From: Thomas Callaway
Sent: 25 August 2016 15:13
To: Planning.Responses
Subject: RE: Planning Consultation on: EG/57/16/PL

Engineers comments in respect to surface water drainage:

APPLICATION **EG/57/16/PL**

Description of Works: Medical centre with pharmacy retail unit & other ancillary uses together with access onto Barnham Road & associated car parking. This application is a Departure from the Development Plan.

**Drainage Strategy &
Soakaway Calculations**

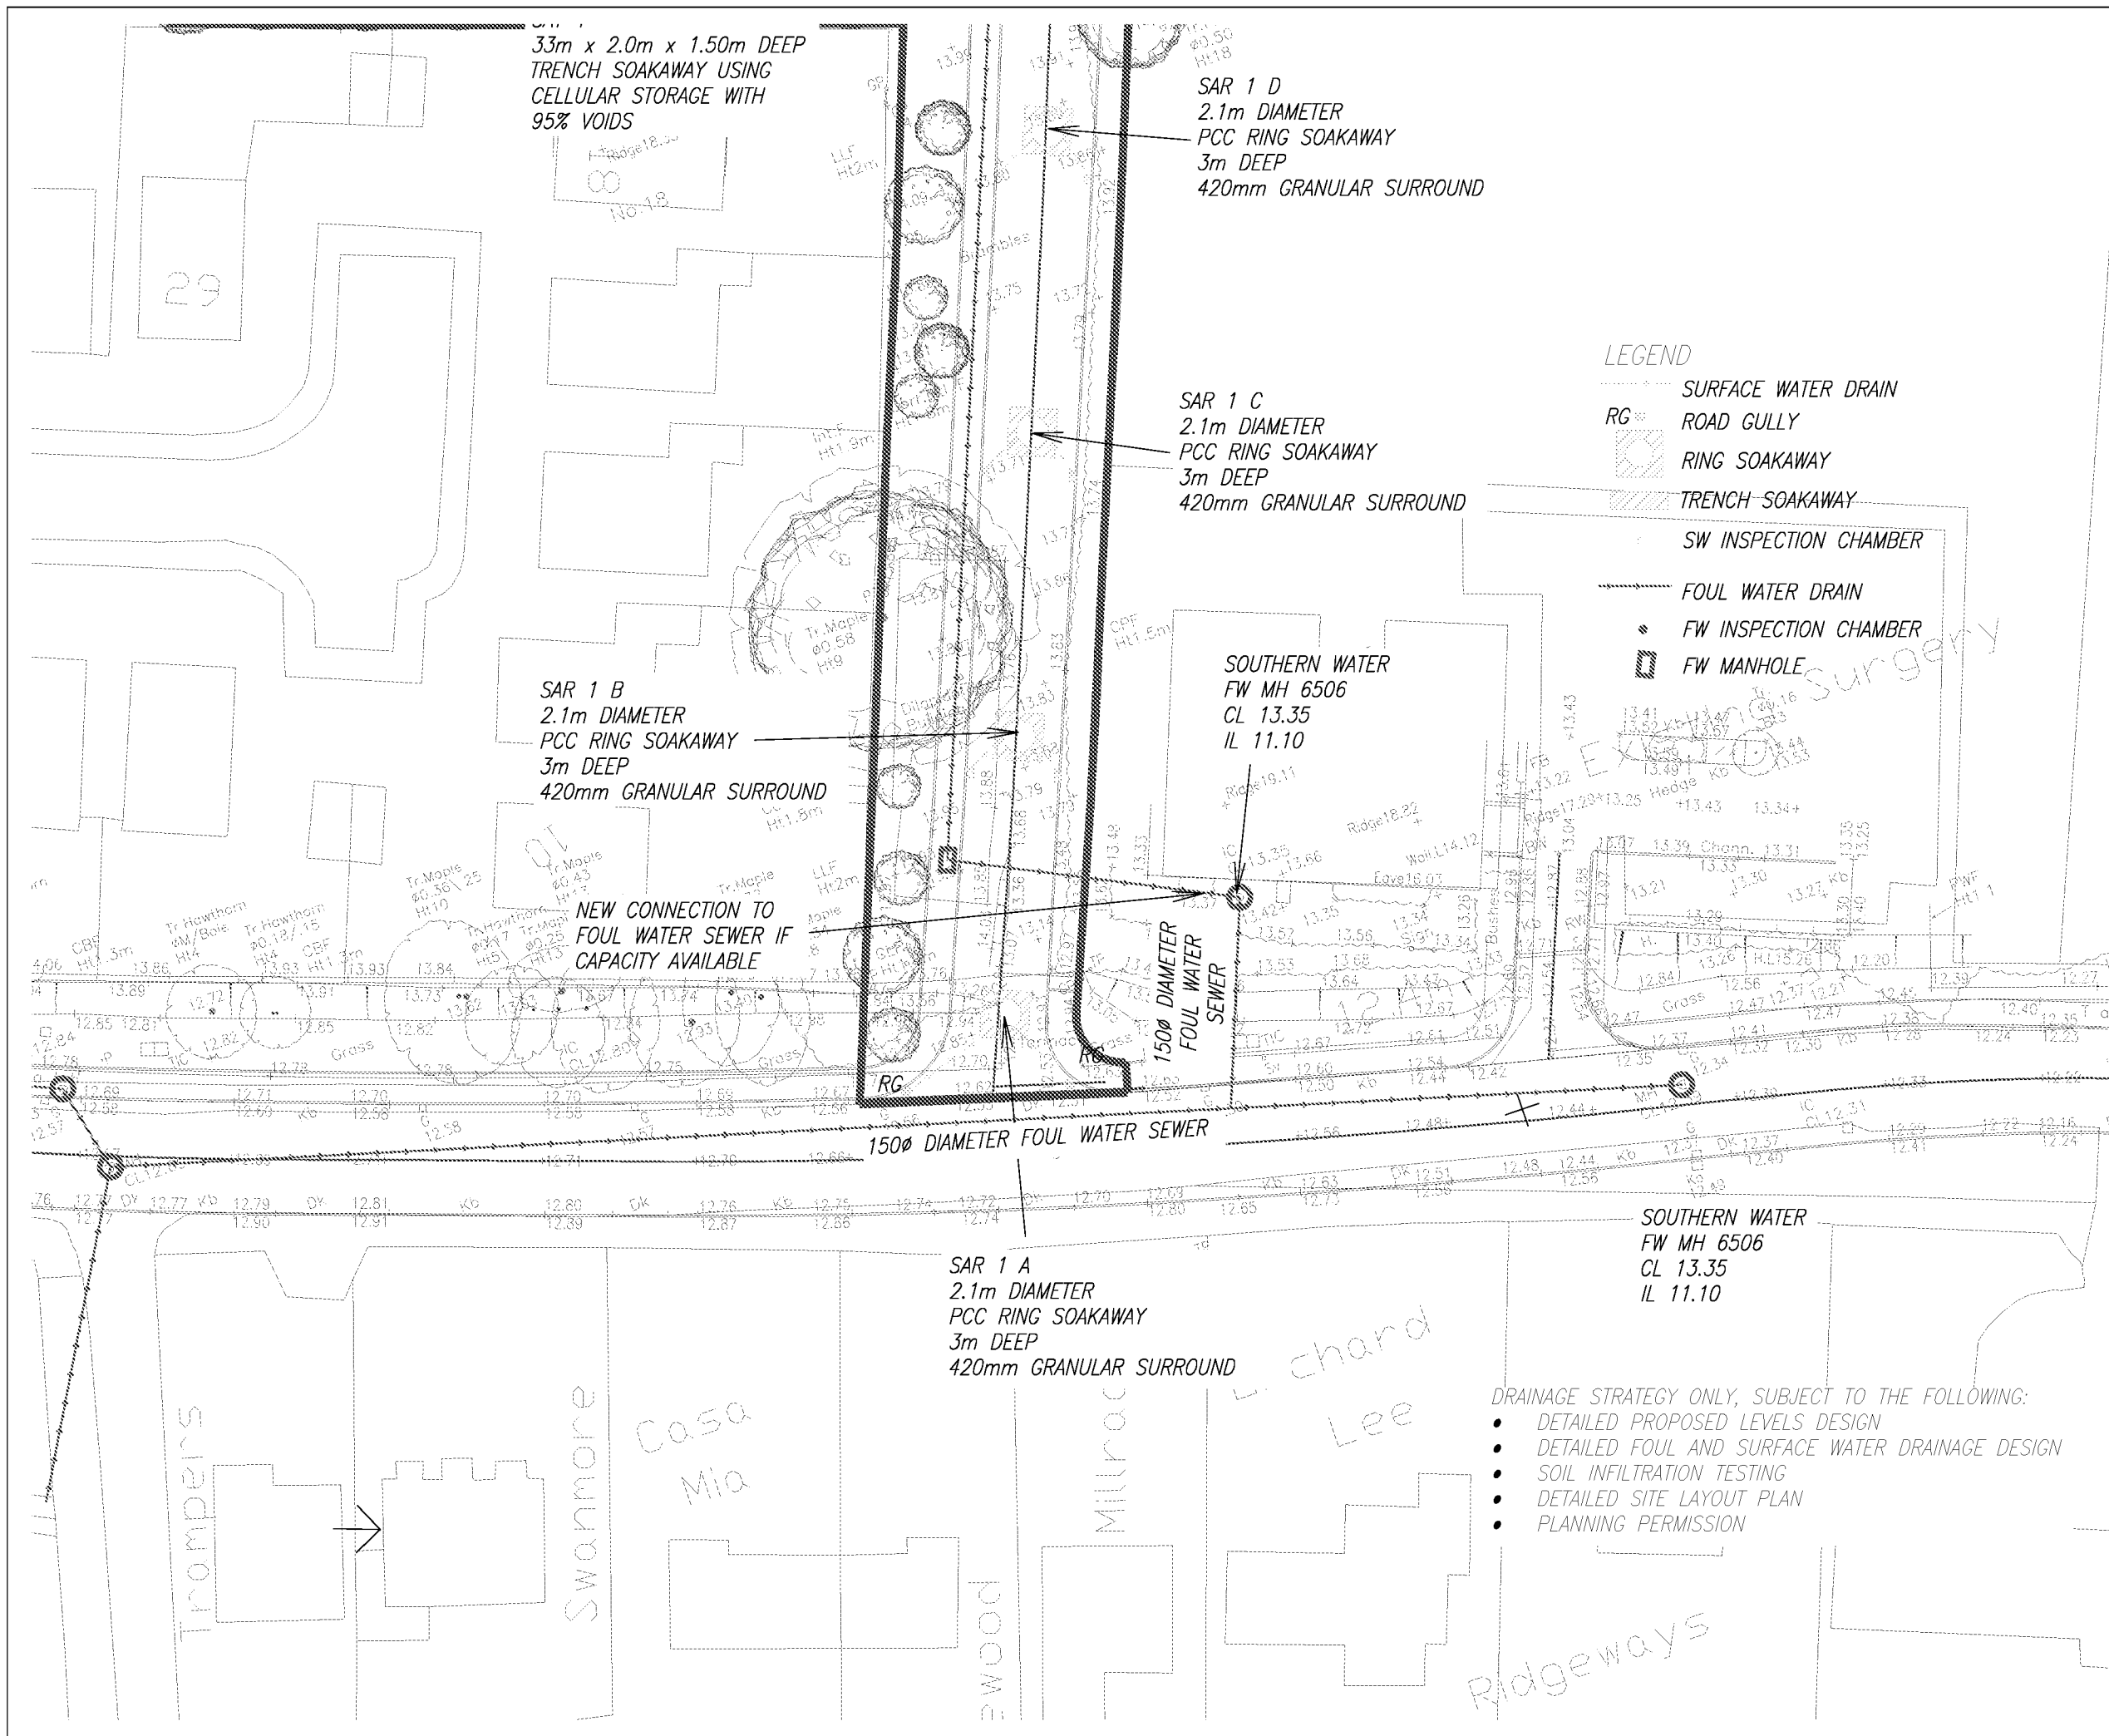
Infiltration to be investigated for surface water drainage of new impermeable areas.

Please apply standard conditions ENGD2A.

Infiltration rates for soakage structures are to be based on percolation tests undertaken in the winter period and at the location and depth of the proposed structures. The percolation tests must be carried out in accordance with BRE 365, CIRIA R156 or a similar approved method and cater for the 1 in 10 year storm between the invert of the entry pipe to the soakaway, and the base of the structure. It must also have provision to ensure that there is capacity in the system to contain below ground level the 1 in 100 year event plus 30% on stored volumes, as an allowance for climate change. Adequate freeboard must be provided between the base of the soakaway structure and the highest recorded annual groundwater level identified in that location.

Any SuDS or soakaway design must include adequate groundwater monitoring data to determine the highest winter groundwater table in support of the design. The applicant is advised to discuss the extent of groundwater monitoring with the Council's Engineers. Supplementary guidance notes are also enclosed for information.
